From: Thomas Callaway
Sent: 20 May 2014 17:15
To: Planning.Responses
Subject: RE: Planning Consultation on R/81/14/DOC

APPLICATION NO: R/81/14/DOC

Registered: 09-APR-14
Site Address: Sainsburys Supermarkets Ltd, Unit C New Road Rustington
BN16 3RT

Description of Works: Application for approval of details reserved by Condition 19 (watercourse) following a grant of planning permission R/59/12/.

CCTV Survey

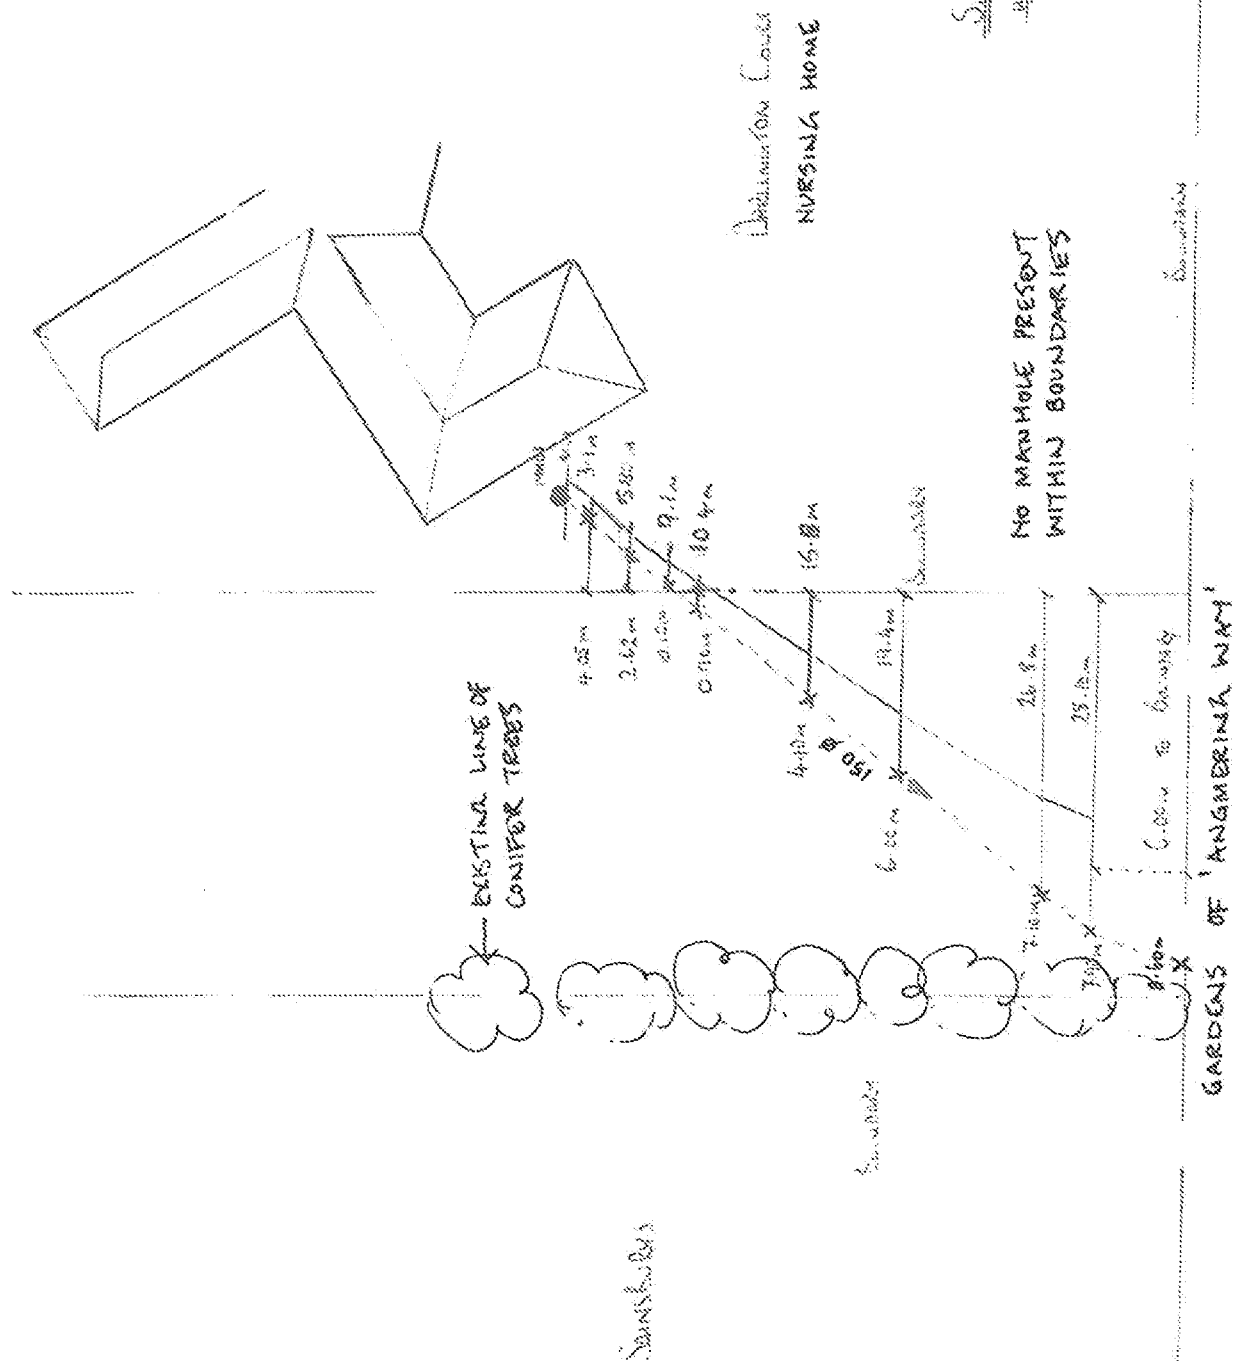
The CCTV survey claims to prove that no buried manholes are within the Sainsburys site, and that the culvert continues beyond the boundary. An annotated map within the survey states that no manholes are present in the south east corner of the nursing home and the south east corner of the Sainsburys site.

We attempted to investigate this early this week and successfully found the buried manhole in the south east corner of the nursing home site, in accordance with our drawings. This was located quickly with a metal detector and our drawings.

The CCTV survey on the Sainsburys site stops short of the boundary by six metres. Any part of the culvert and any buried manholes would be within six metres of the boundary according to our drawings. It is difficult to tell due to the dumped spoil in this part of the site, but the manhole may be beneath the small section of fence screening some of the apparatus on site.

Once located, the manhole should be raised, and further CCTV surveying/jetting should be undertaken to determine the length of culvert within the site. This is in line with the Condition as it is necessary for future access and maintenance. We anticipate that the culvert runs close to the boundary fence line rather than in the gardens the other side, but this should be investigated.
